Your reference: 3/2016/0022
Our reference: 2016/02/024

**RE: 1 & 2 Abbeycroft, The Sands, Whalley (Grade II, C17, refronted C19);
application for the erection of a rear extension**

drawing title:  
 EXISTING AND PROPOSED DRAWING

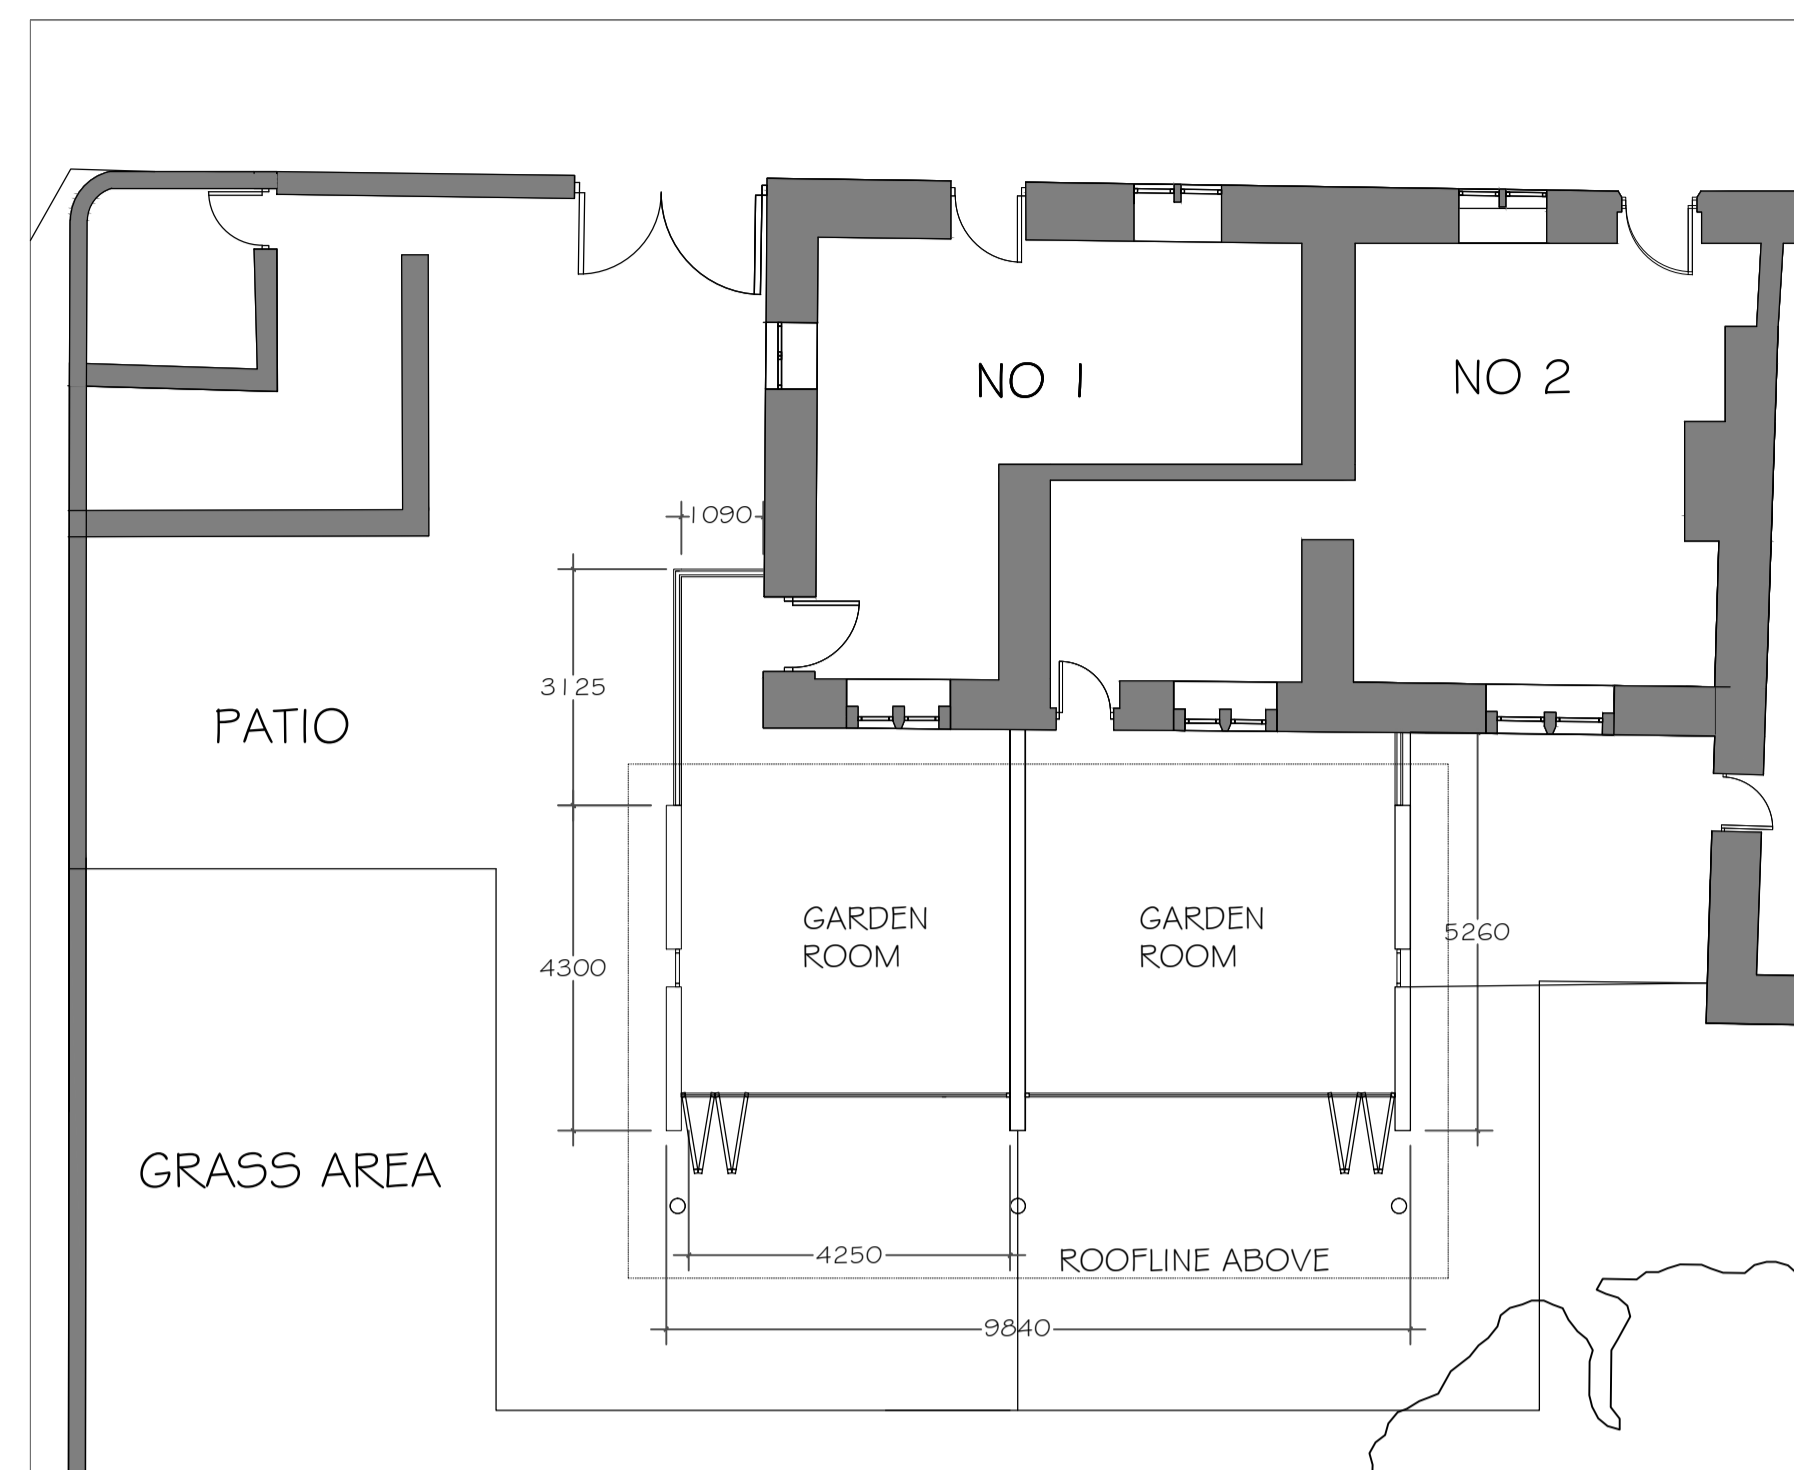
Thank you for consulting the Victorian Society on this proposal. We **object** to this application, which would cause harm to the character and appearance of the listed building.

The Society seldom comments on proposals for single-storey rear extensions to listed buildings. However, in this case, the impact of the proposed extension would be such that we are compelled to object. We endorse the views articulated by Peter Iles in his letter to the Council of 17 February. While a modest and carefully detailed single-storey extension may be acceptable here, what is proposed would inevitably detract from the character and appearance of the listed building. Its footprint is too large, causing it in plan to protrude beyond Abbeycroft's north wall. In addition, it would almost double the depth of the property. The large expanse of glazing proposed would not be invisible, as indicated on the drawings; rather, the highly reflective surfaces would conceal much of the historic building, would draw attention from the subtle play of light and colour on the historic rubble walls and would appear unnecessarily strident. Furthermore, the construction of such a large extension in this location would inevitably erode the visual rhythm and relationship of the four cottages as seen from the north west. It also risks justifying the construction of additional inappropriate extensions to the other cottages, thereby risking further harm to the character of the listed building.
